## THE COLONG FOUNDATION FOR WILDERNESS LTD.

### **Re: Springvale Water Transfer and Treatment Project SSD 16\_7592**

Figure 1. An overview of the proposed piping layout to divert wastewater from the Newnes Plateau to the MPPS [3]

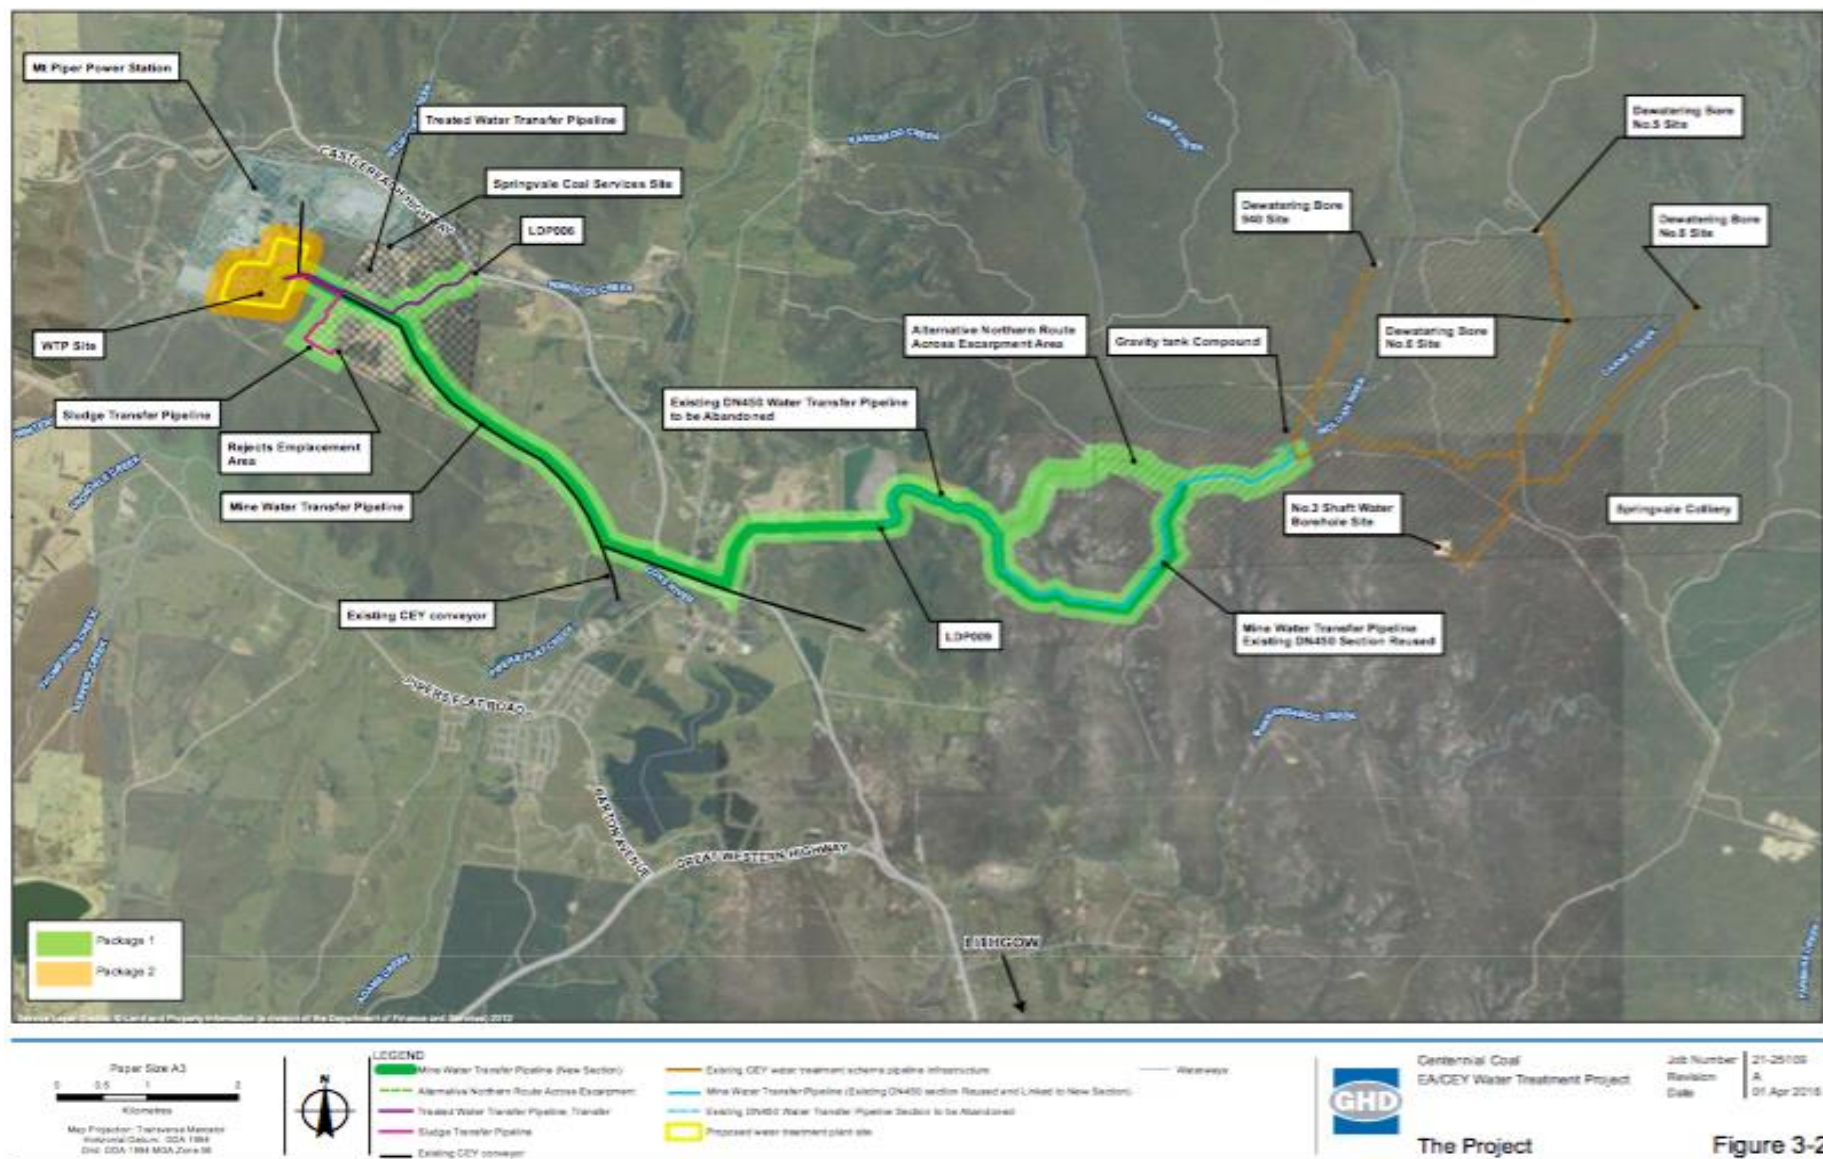
The consent for the proposed new pipeline should be required to follow the existing SDWTS pipeline alignment off Newnes Plateau to prevent unnecessary damage to a scenic and ecologically important part of the Gardens of Stone region known as the Clerestory Spurs that link downslope with an EEC community beside Sawyers Swamp Creek.

On face value, the EIS conclusion that a new pipeline following an existing pipeline route will have greater environmental impact than establishing a new pipeline route is not credible. The comparison between the existing pipeline route and new route is flawed, as disturbance of the existing easement environment should have discounted impacts when compared to those of the proposed new easement. If the new easement is to save money or to ensure pipeline reliability, or if the old route was found to be unsuitable for further development, then these reasons should have

Existing transfer pipeline enters Sawyers Swamp Creek valley from the west (figure above), the proposed pipeline would enter this valley from the north causing unnecessary environmental disturbance (figure below from the 2014 Springvale Mine extension EIS).

*Proposed pipeline and road route descends through a gully that lies between Clerestory Spurs 7 and 8 and then proposes to clear MU11, an endangered ecological community. How can this be less damaging than following the existing pipeline easement, and what are the justifications for pipeline relocation? (figure below from the 2014 Springvale Mine extension EIS).*

1. The existing pipeline easement from the balance tank on Newnes Plateau to LDP009 should be used by any future pipeline.
2. The operator of Mt Piper Power Plant must store all surplus mine water in its storages.

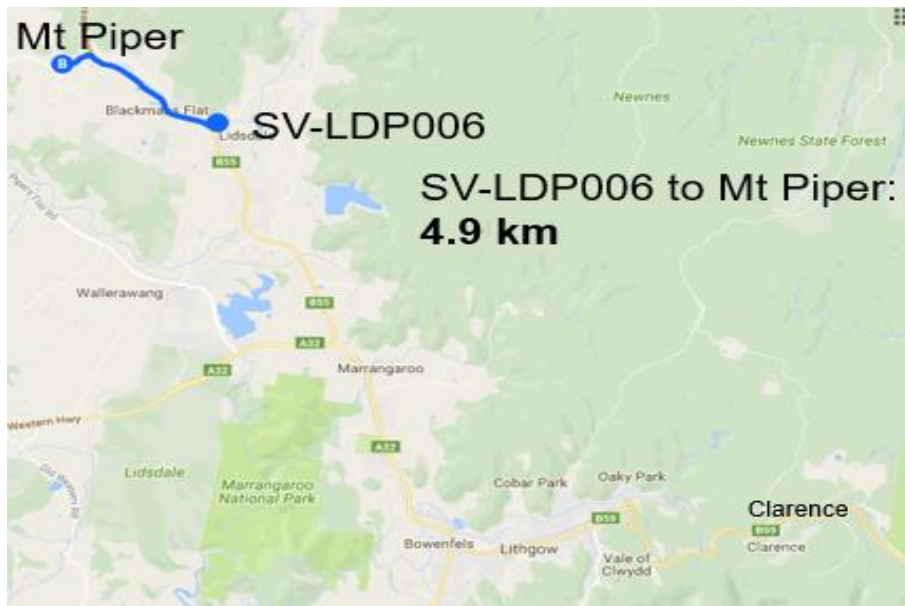
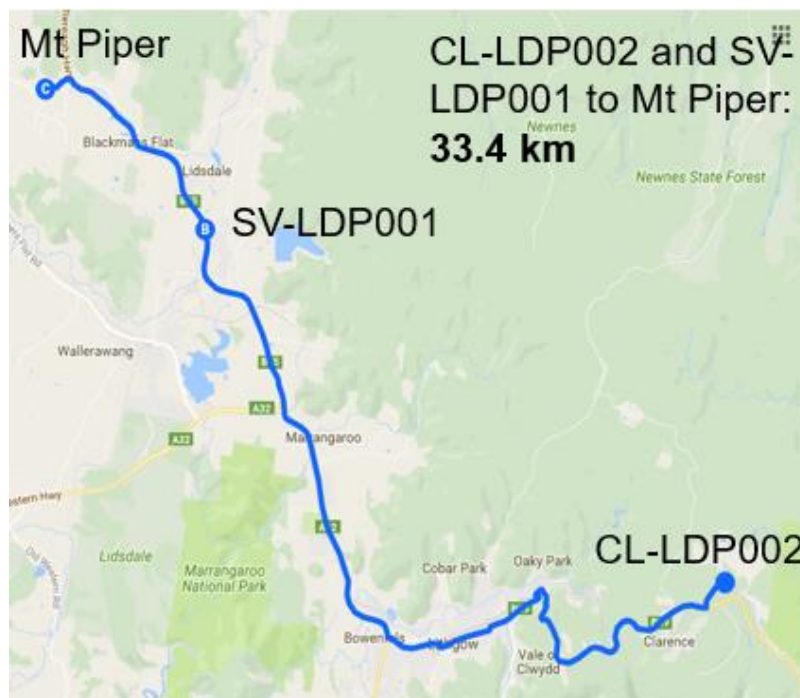
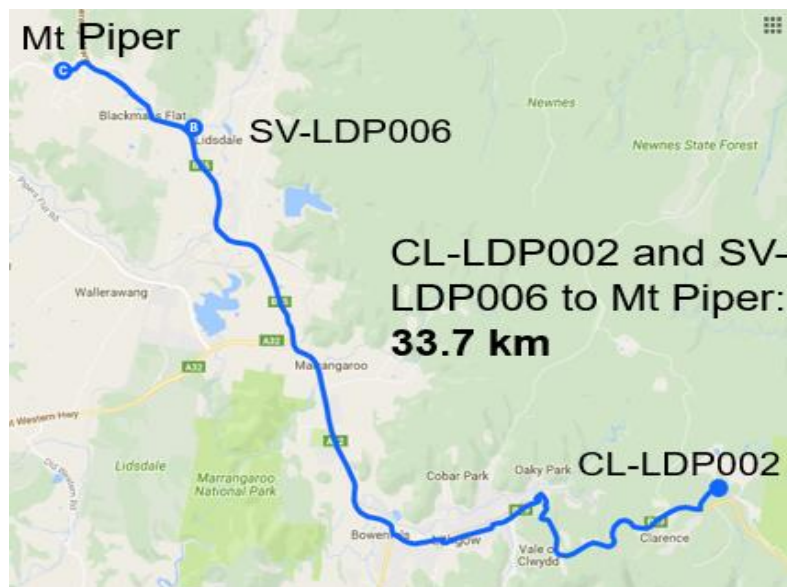
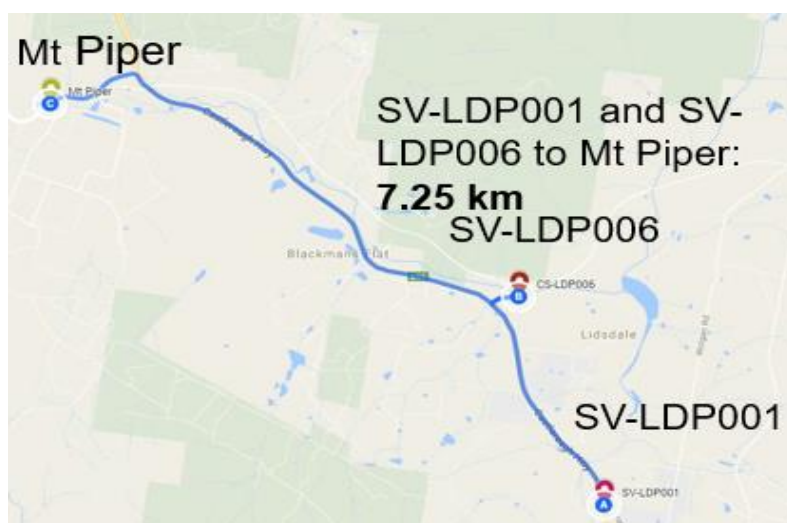
In addition to the mine water transfers, LDP 006 and the storage proposal at Thompsons Reservoir, an expansion of the Springvale mine water transfer proposal should include capacity for Clarence Colliery mine water transfer. Such an enlarged pipeline would enable Centennial to meet upgraded EPL renewal requirements for Clarence colliery.

The pipeline should have capacity for an additional 15ML/day of mine water from Clarence Colliery to clean up the Wollangambe River.

5. The operator of Springvale Mine must construct the mine water transfer pipeline with sufficient capacity to accept transfers from the Clarence Colliery.
